TECHNICAL NOTE

Project Title: Ridham Dock

Report Reference: JNY10115-04

Response to Kent County Council Highways and Highways England

Drawing  
ENGINEERING LAYOUT  
8 ACRES SITE

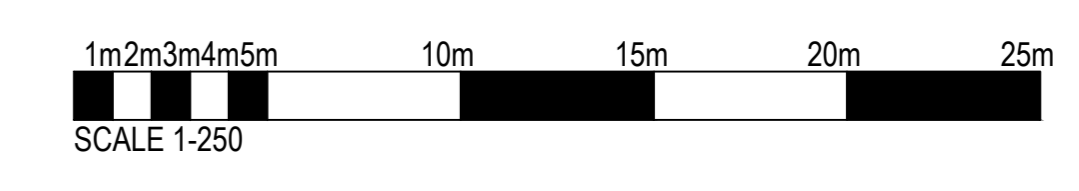
- 1.42 The proposed layout is shown at **Appendix E**. The turning circle shows the ability of articulated HGVs to turn within the site. The length of the access road between the weighbridge provides space for 2 HGVs to be held prior to weighing. There will be a total of 9 HGVs per hour arriving at the proposed development. Over the course of the hour this allows for over 6 minutes for each

HGV to use the weighbridge. HGVs typically require a few minutes each to be weighed and processed over the weighbridge. When taking into account an HGV on the weighbridge and space for 2 HGVs to wait prior to weighing there is sufficient area and time for HGVs to be processed without queueing back through the main gate.
